Application for a non-material amendment following a grant of planning permission.

Number	
Suffix	
Property name	Land At Salt Box West Of
Address line 1	Shripney Road
Address line 2	
Address line 3	
Town/city	Bognor Regis
Postcode	PO22 9NW
Description of site location must be completed if postcode is not known:	
Easting (x)	493790
Northing (y)	101639
Description

BE/135/18/PL

Dock doors adjusted to suit tenant requirements (bay 12 enlarged, bay 13 lowered)
Dock levellers added at docks 1-11 and 14-23
Dock shelters shown
Landscape layout and levels adjusted to suit consented strategy

SALT BOX SITE - BOGNOR REGIS

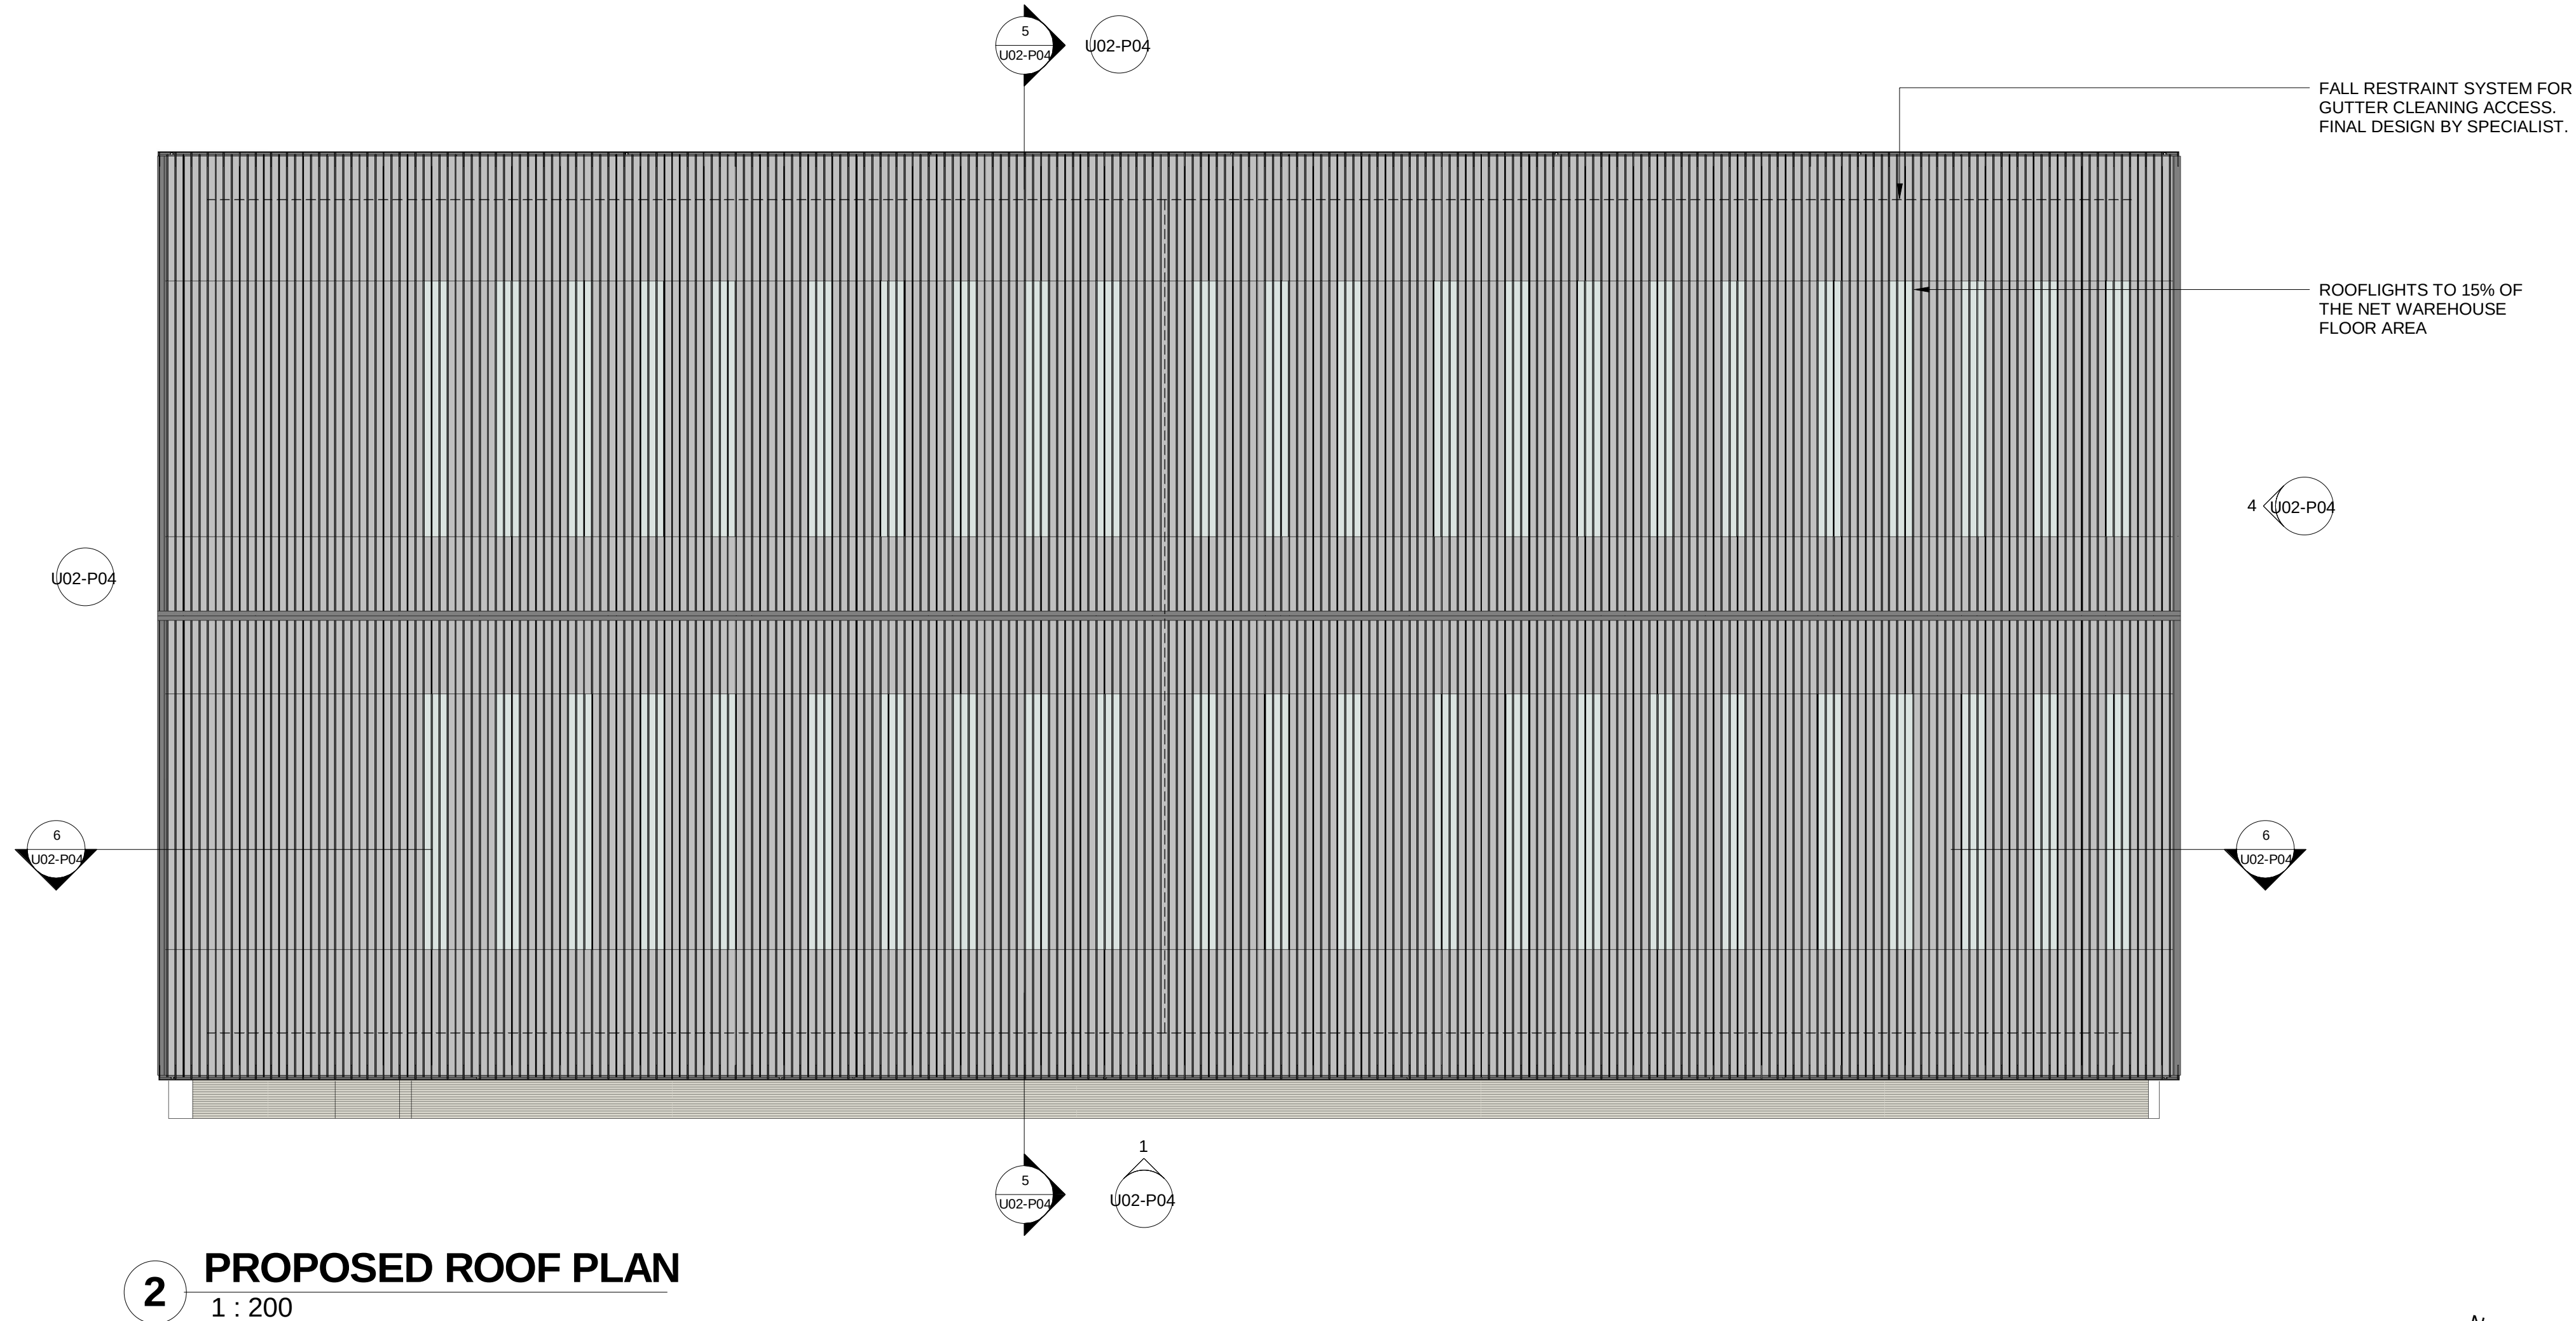
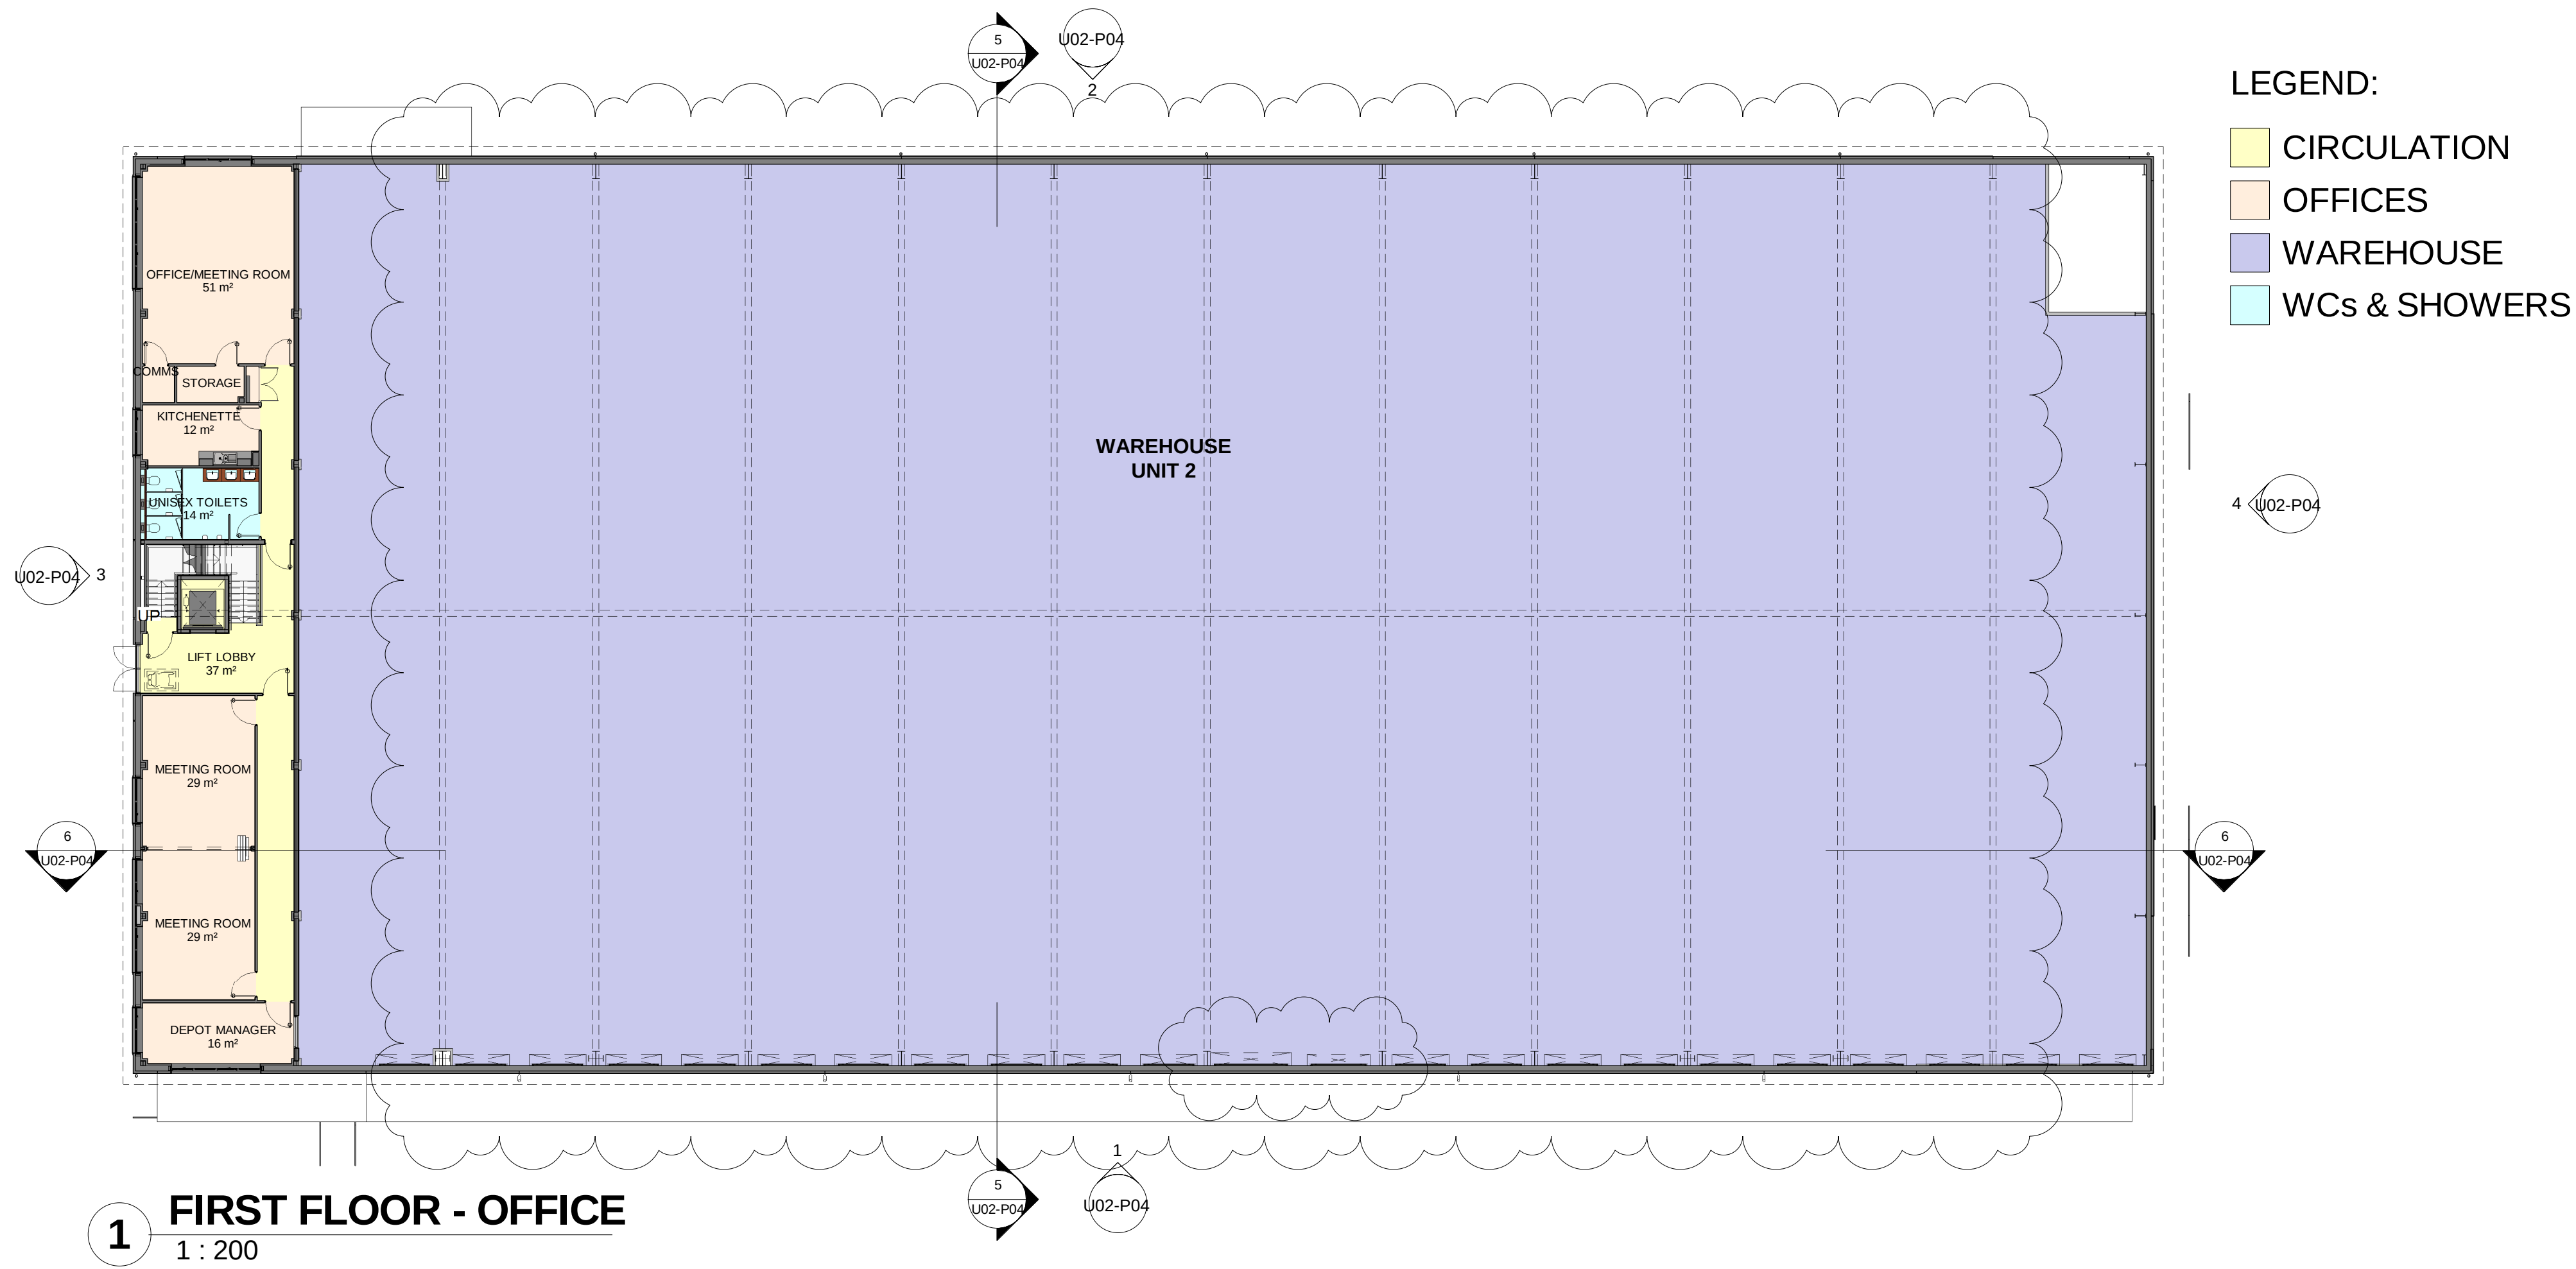
The tenant requested the changes to the dock doors/levellers to aid their future flexibility with delivery vehicles.
Dock shelters not previously shown on planning elevations.
Landscape adjustments to suit civil engineering strategy for flooding and drainage.
